Planning Application No: 3/2024/0239

Proposal: Proposed construction of new two-storey three-bedroom dwelling in garden, with new access and associated alterations to original dwelling.

Location: Moorcot, 24 Nickey Lane, Mellor BB2 7HF

VISIBILITY SPLAYS 1:500

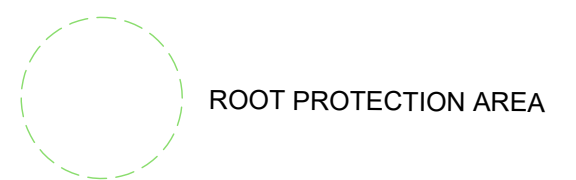
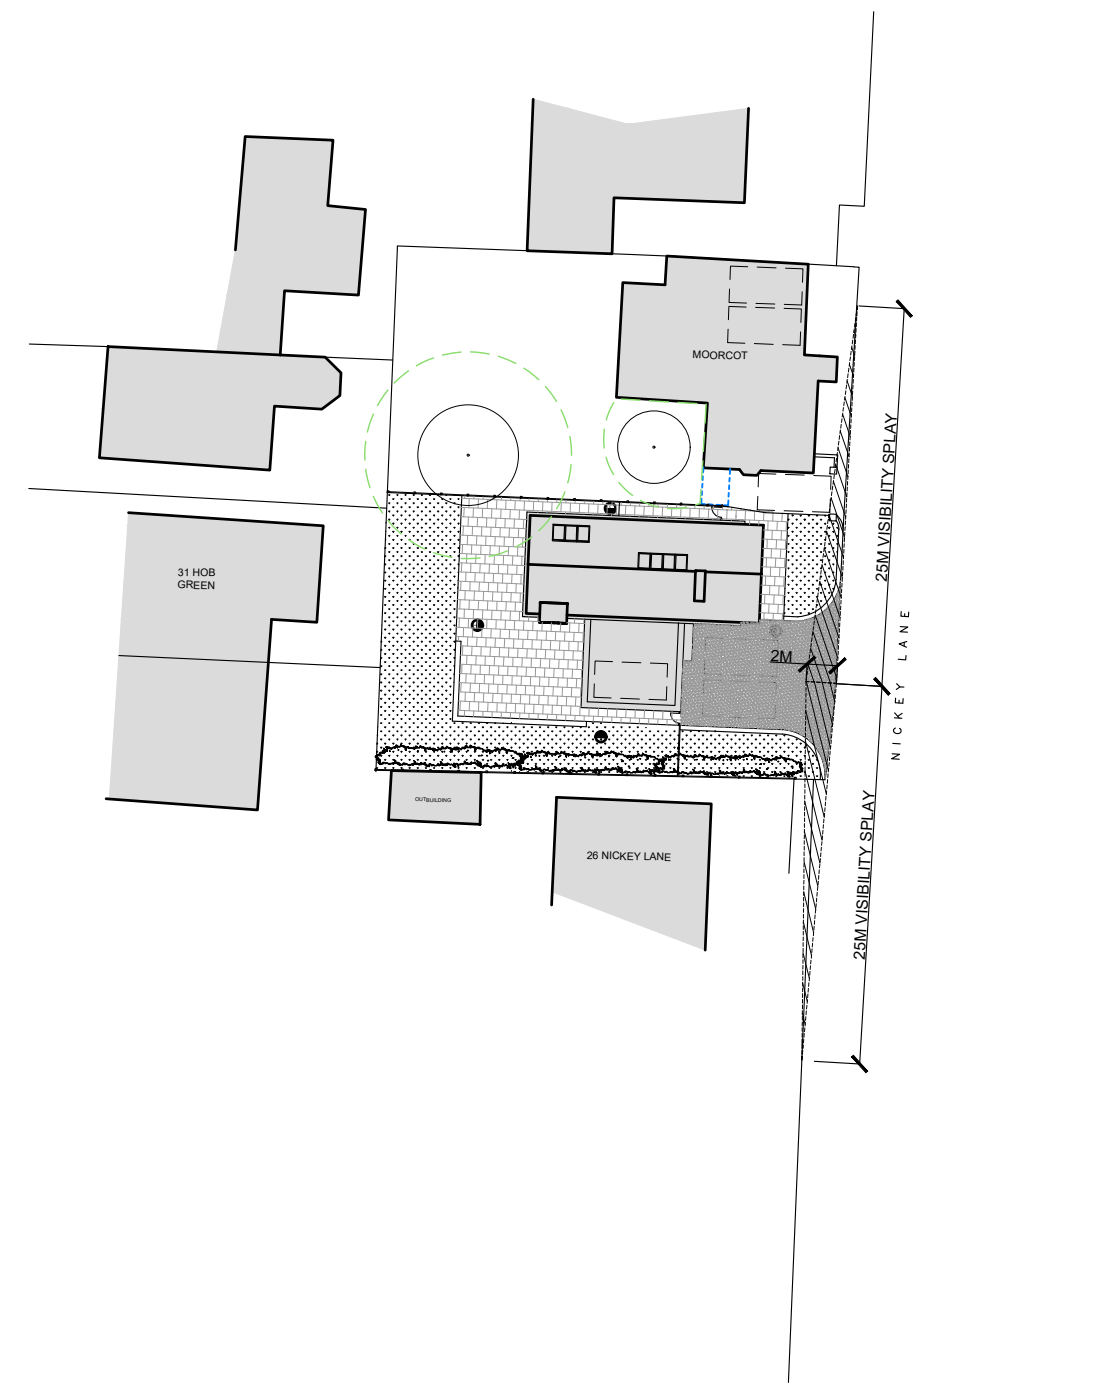
Nickey Lane is subject to a 20mph maximum speed limit outside the site, for which visibility splays of 25m in each direction would be required from the new access. (Manual for Streets.)

Visibility splays should be over land within the applicant's ownership and/or the publicly maintained highway network. No part of the splays should be over third party land.

A revised visibility splay plan should be submitted taking account of the above comments. If adequate visibility splays cannot be achieved that the highway authority would object to the proposed development on highway safety grounds.

PROPOSED SITE BLOCK PLAN 1:200

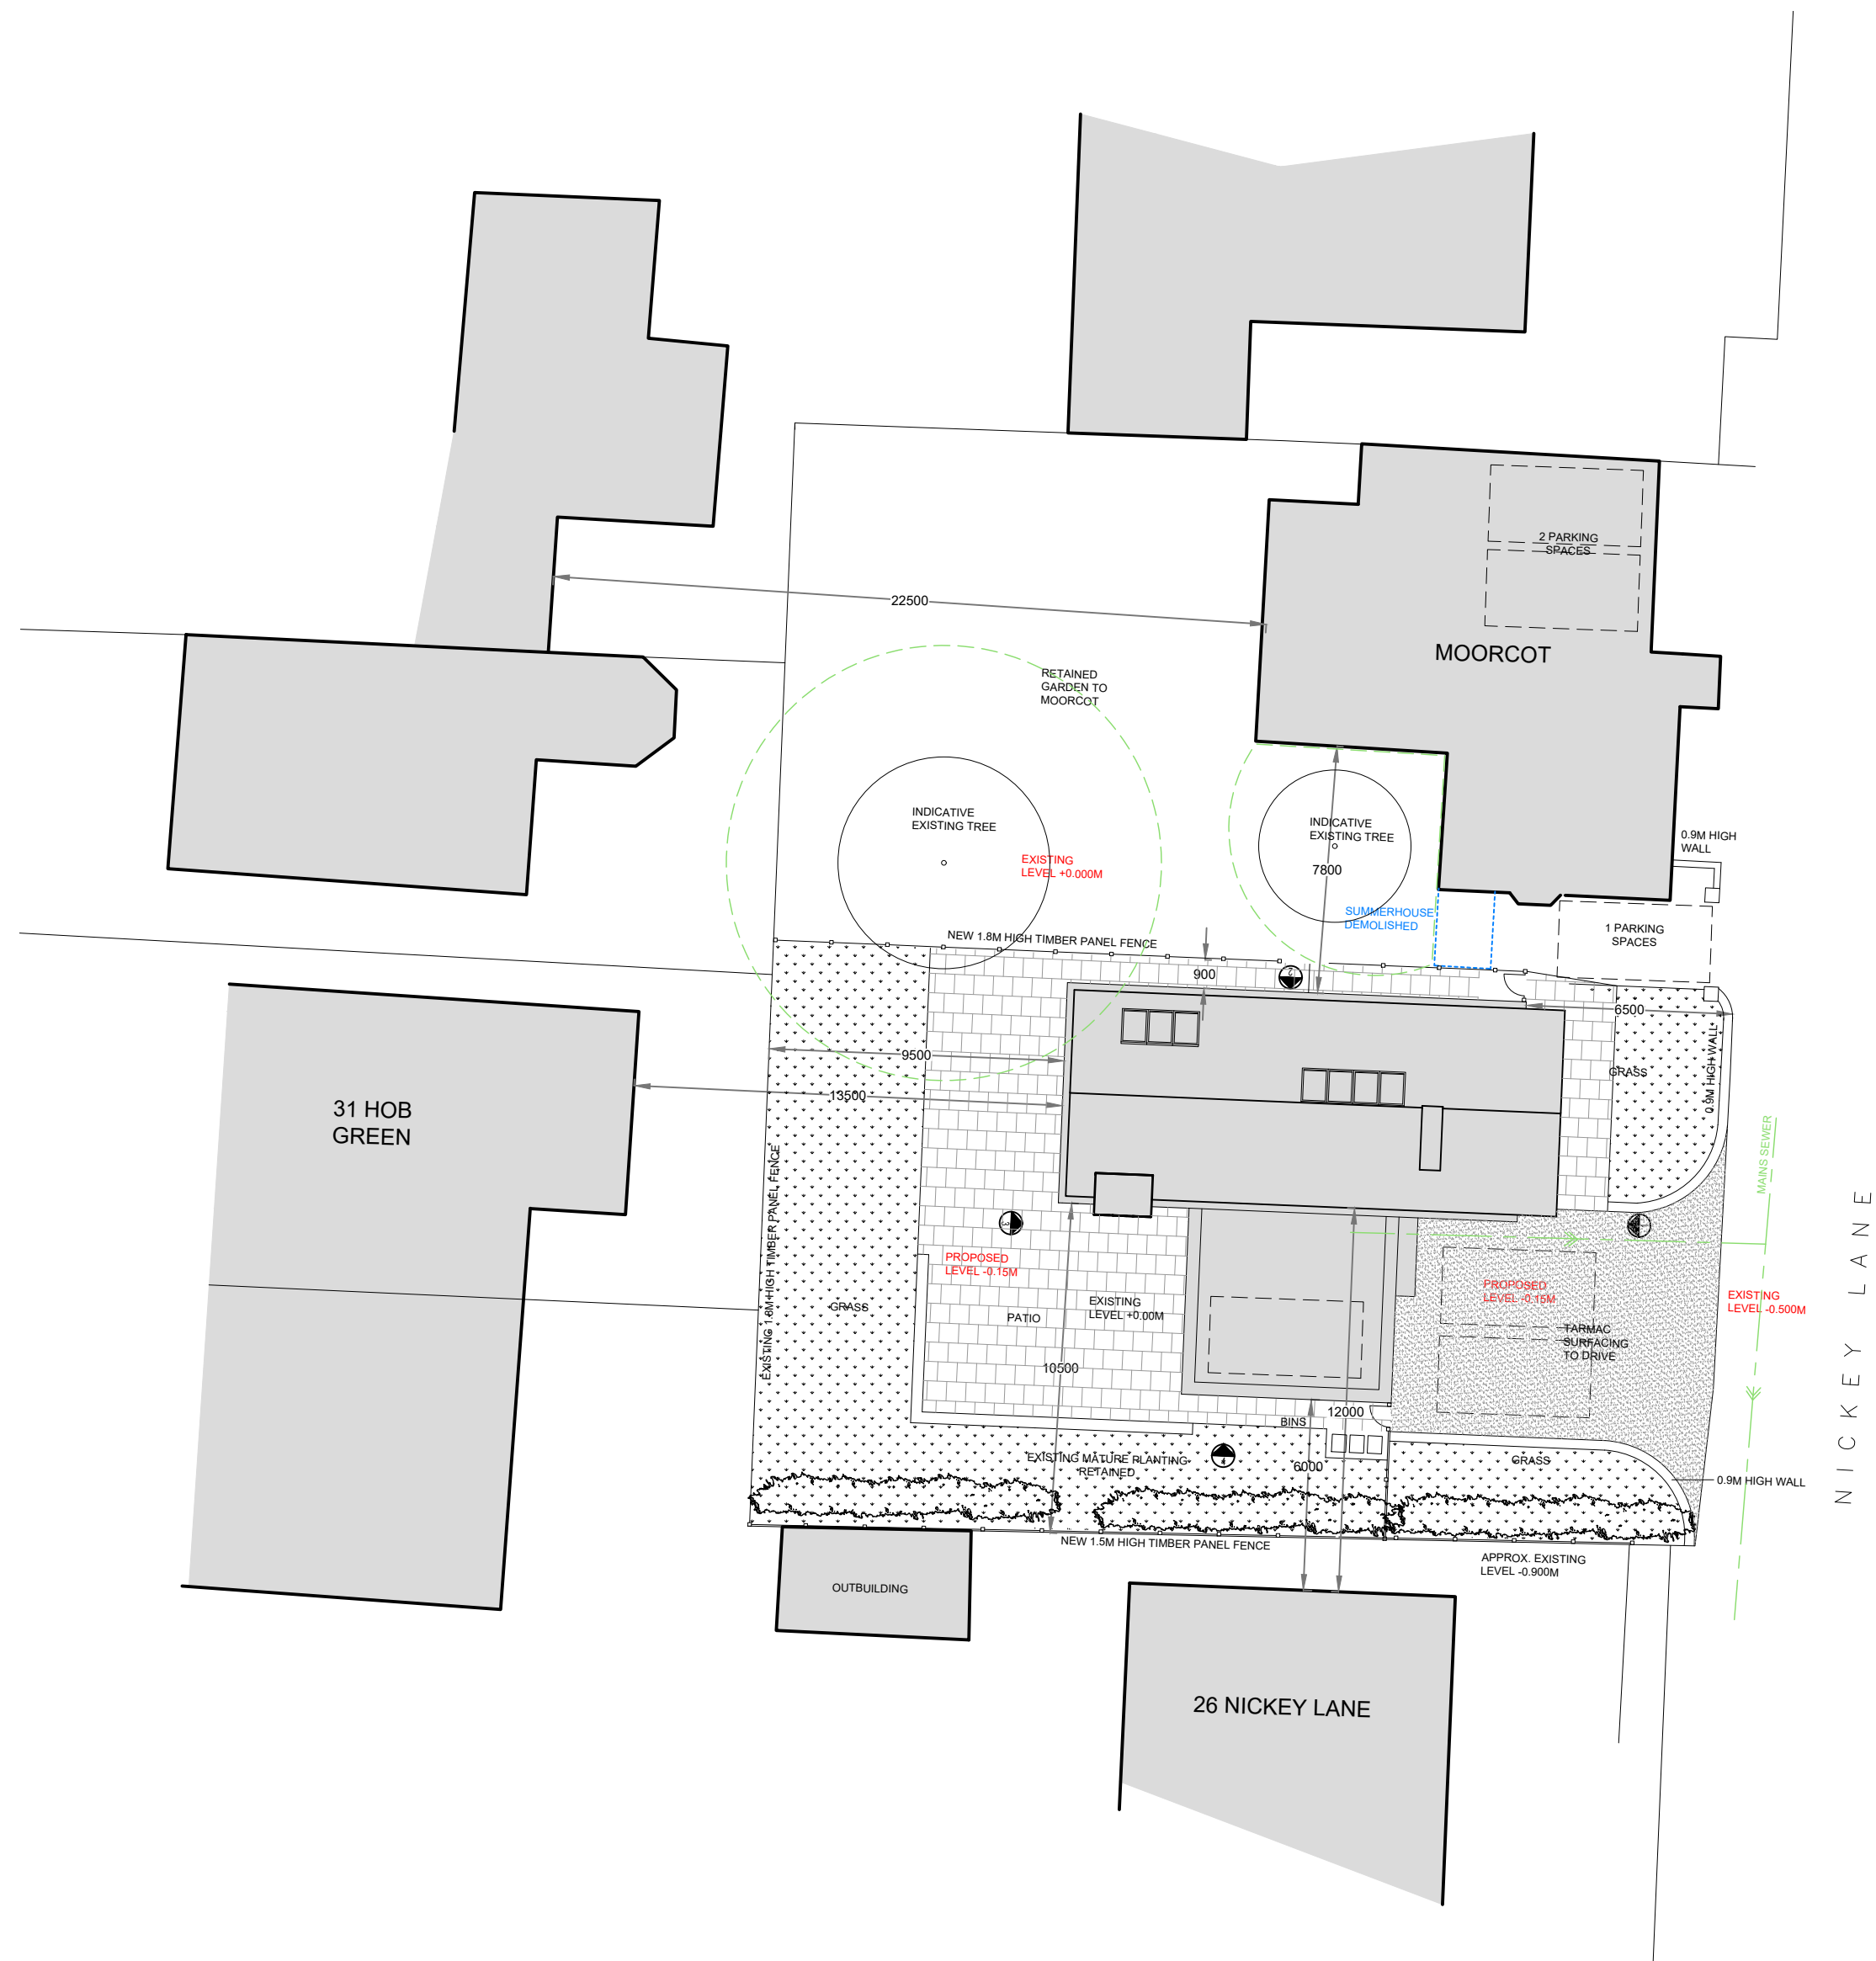
New vehicle access & highway works

The formation of the new vehicle access from Nickey Lane to the development site would need to be carried out under a legal agreement (Section 278) with Lancashire County Council as the highway authority. Works should include, but not be exclusive to:

- the construction of the access to an appropriate standard, including radius kerbs,
- the construction to an appropriate standard of two sections of new footway 1.8m wide either side of the access (approx overall length of 10m) to improve pedestrian access and safety,
- buff coloured tactile paved dropped pedestrian crossings either side of the access,
- minor widening of the existing carriageway to the county council's specification across the site frontage.

The highway authority considers that two adequately sized off-road car parking spaces should be provided for a three bed dwelling. The proposed single garage is considered adequately sized internally to provide one car parking space and secure storage for at least two cycles. A further two spaces can be provided on the driveway/hardstanding in front of the garage. The highway authority therefore considers that an adequate level of off-road parking has been provided.

The new driveway shall be constructed so that surface water does not flow onto the public highway. If this is not possible then surface water should drain to an internal outfall. No connection to Lancashire County Council's highways drainage system is permitted.
